Q.5.4.0.1 Projects included in cumulative impact assessment

Answer 5.4.0.1 Oulton Parish Council

B1149 - Cable Crossing

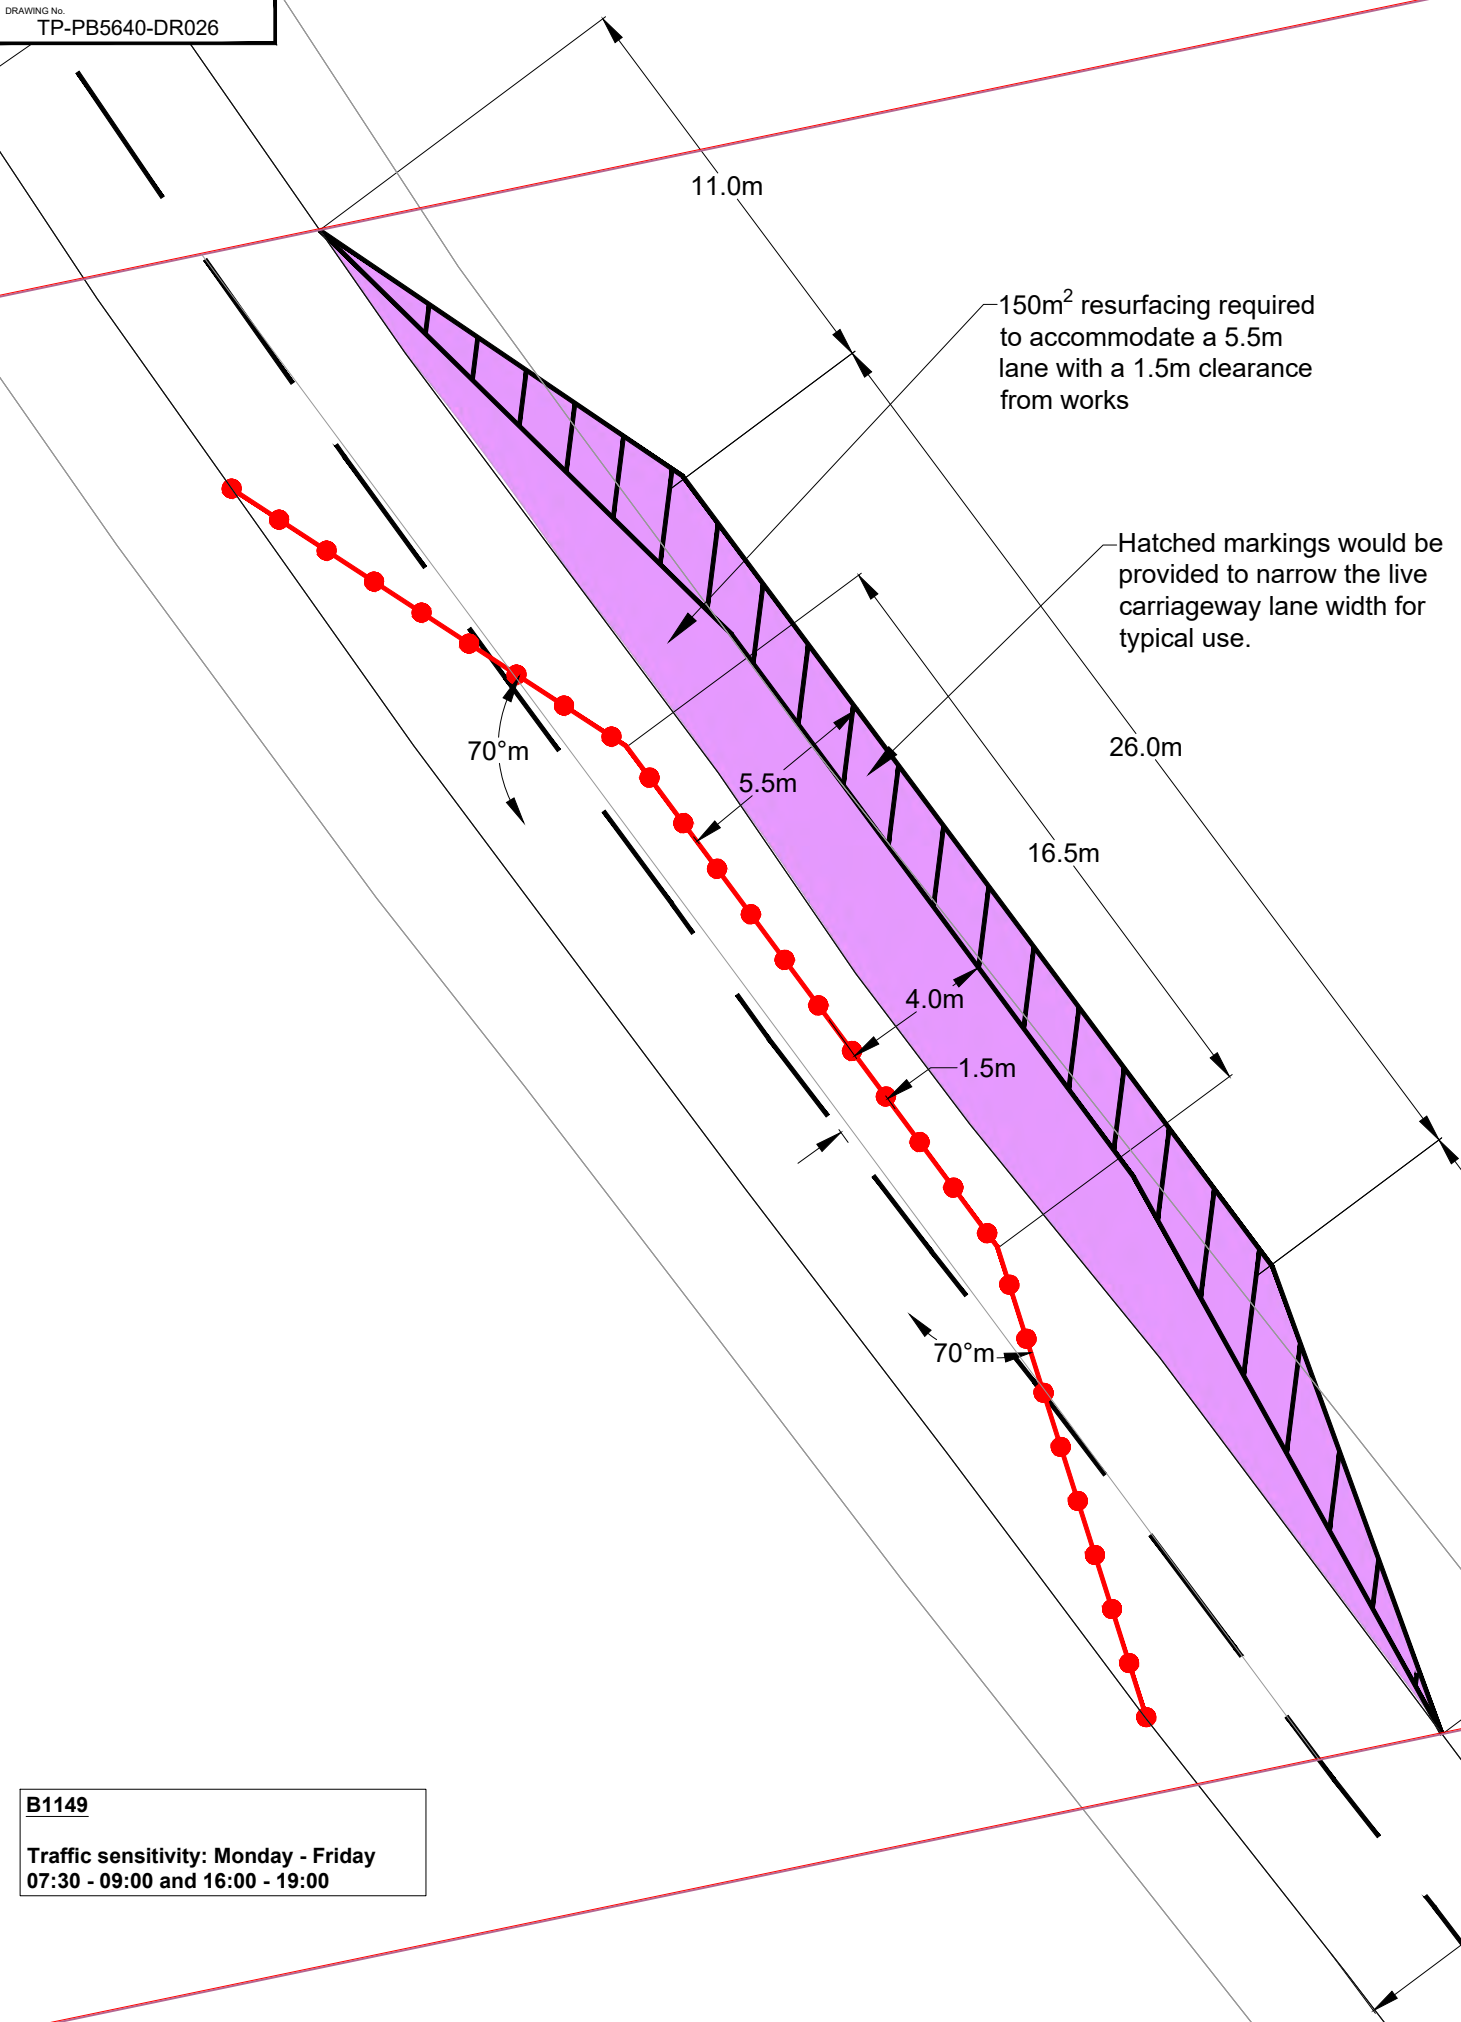
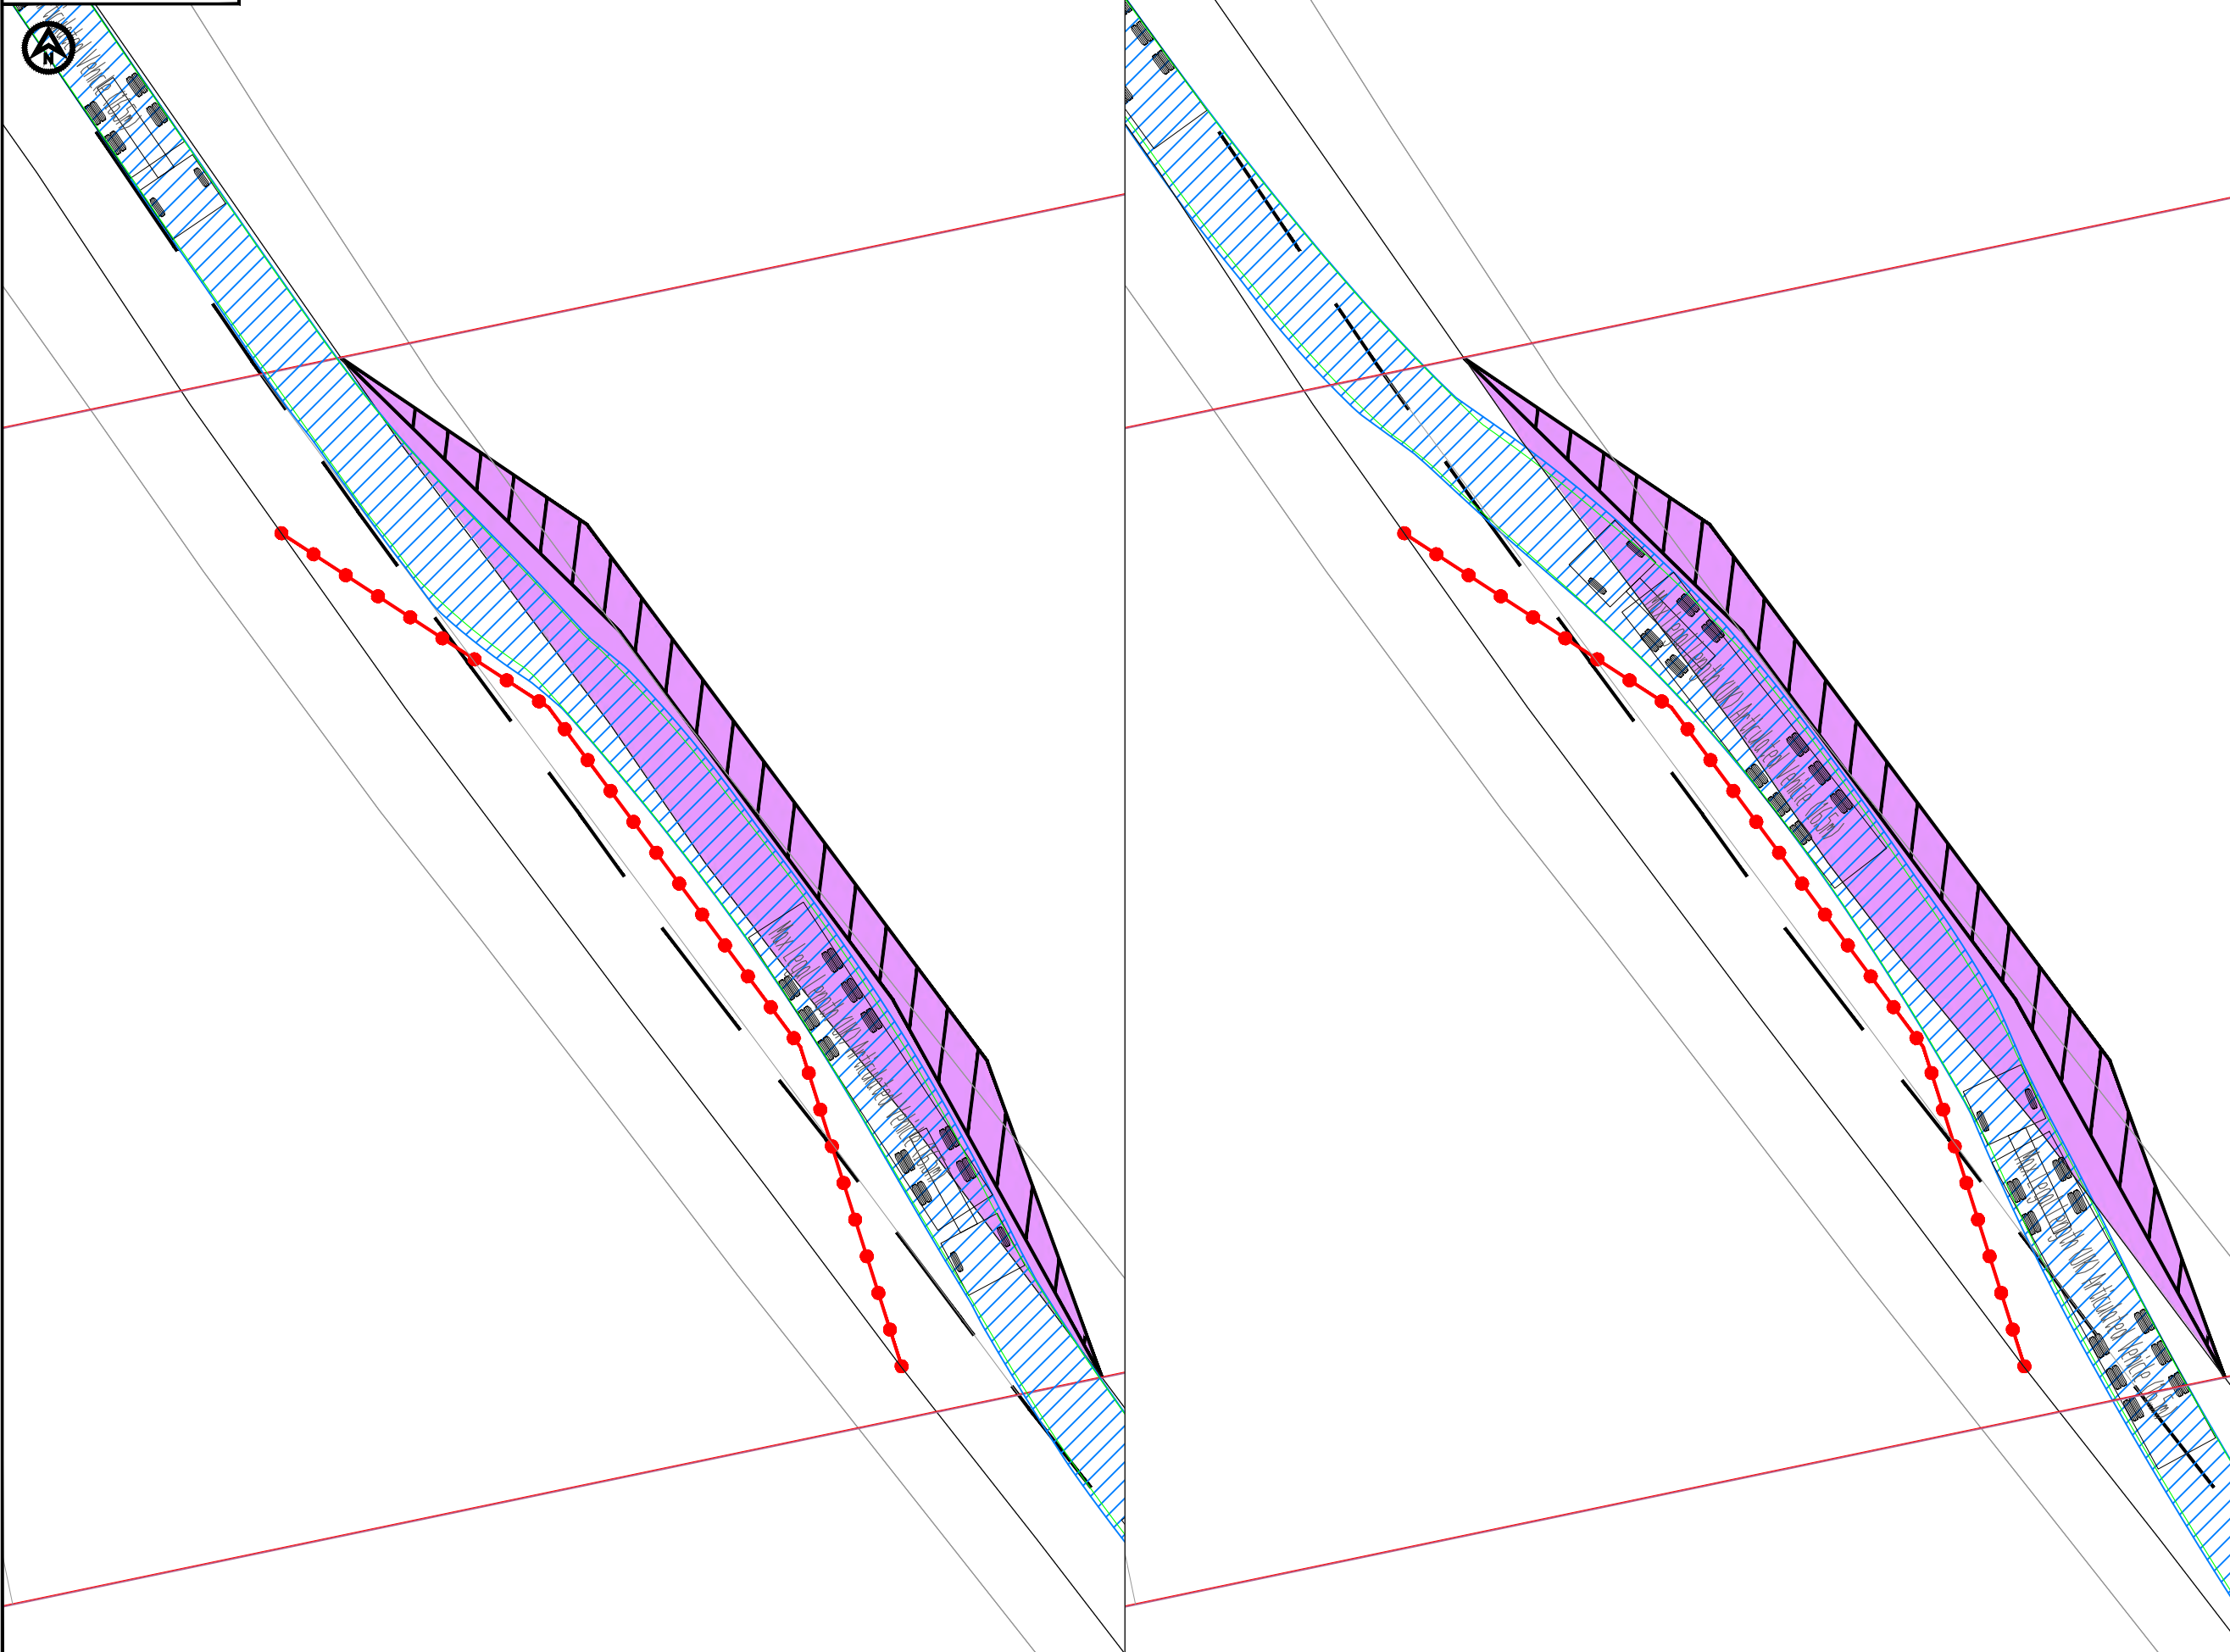
b) Requirement 16. trench-less crossing of B1149

OPC feels there is still some confusion as to whether the new requirement for a trench-less crossing is only required if Hornsea Three proceeds to construction, or if the requirement is irrespective of HOW3.

The implication here is that trenchless crossing might NOT be required if HOW3 does not go ahead.

OPC query the wisdom of this, as it was **NCC** who were concerned about the integrity of the road, post trenching work, under any circumstances.

If HOW3 does not proceed there remains an issue of very large agricultural traffic regularly using the B1149 during trenching work, which would have difficulty manoeuvring around the road works (combines, potato harvesters, pea viners etc.).

Norfolk Boreas is still proceeding with Scenarios 1&2 so there is still the need to consider Vanguard/Boreas Scenario 1 or Scenario 2 as well as Boreas Scenario 1 with SEP/DEP. The Applicant has consistently under-estimated the importance of the B1149 as a radial route from Norwich to the coast, and OPC feel that the trench-less crossing should be included in the DCO, regardless of whether it is in combination with HOW3 or is a standalone project.

In any case, NCC Highways has always strenuously maintained that it would be ill-advised to disturb the integrity of the substructure of the road by trench-cutting as, given the volume of heavy and agricultural traffic, the road surface would be liable to subsidence thereafter.

(t) In circumstances where the Hornsea Three Off-shore Wind Farm Development Consent Order is made and its development commences, there shall be trench-less crossing of the B1149 (Work No. 6).
